Our reference: P-1130674-R9R6
Contact: Robert Craig
Telephone: (02) 4732 7593

SSD-78665709-Mod-1 – Design Amendments to Proposed In-Fill Affordable Housing at 160-172 Lord Sheffield Circuit, Penrith

APPENDIX: A.1 GROUND FLOOR PLAN SNAPSHOT – BIN STORAGE AREAS

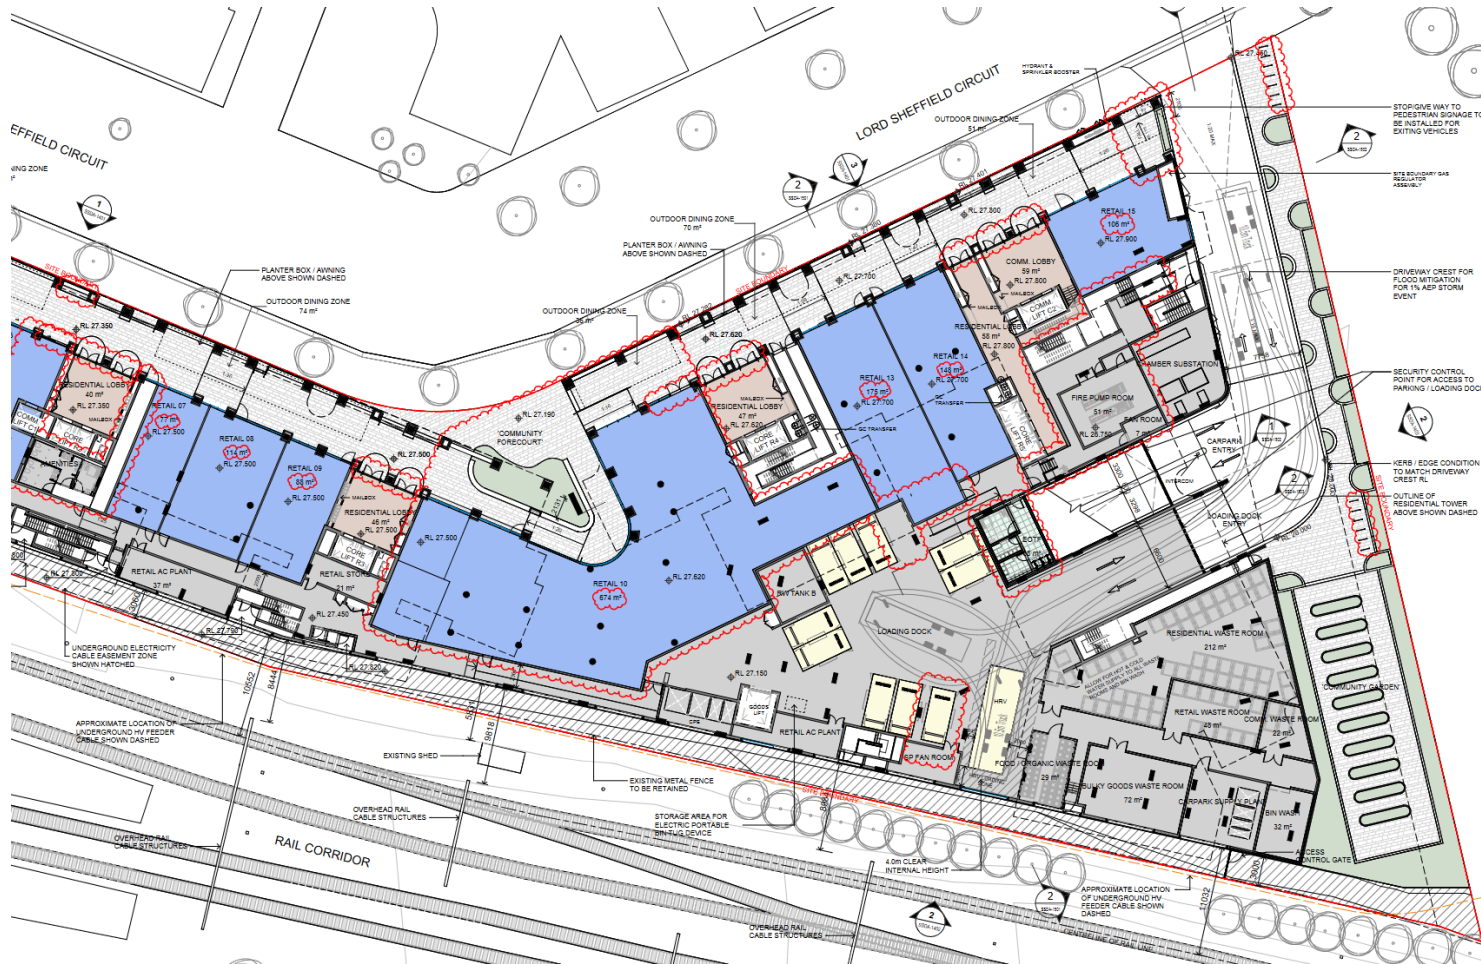
- a) An additional ground floor planter box is proposed adjacent to the site access driveway. The height of the planter box must not obstruct driver sightlines as per AS 2890.1 and AS 2890.2.
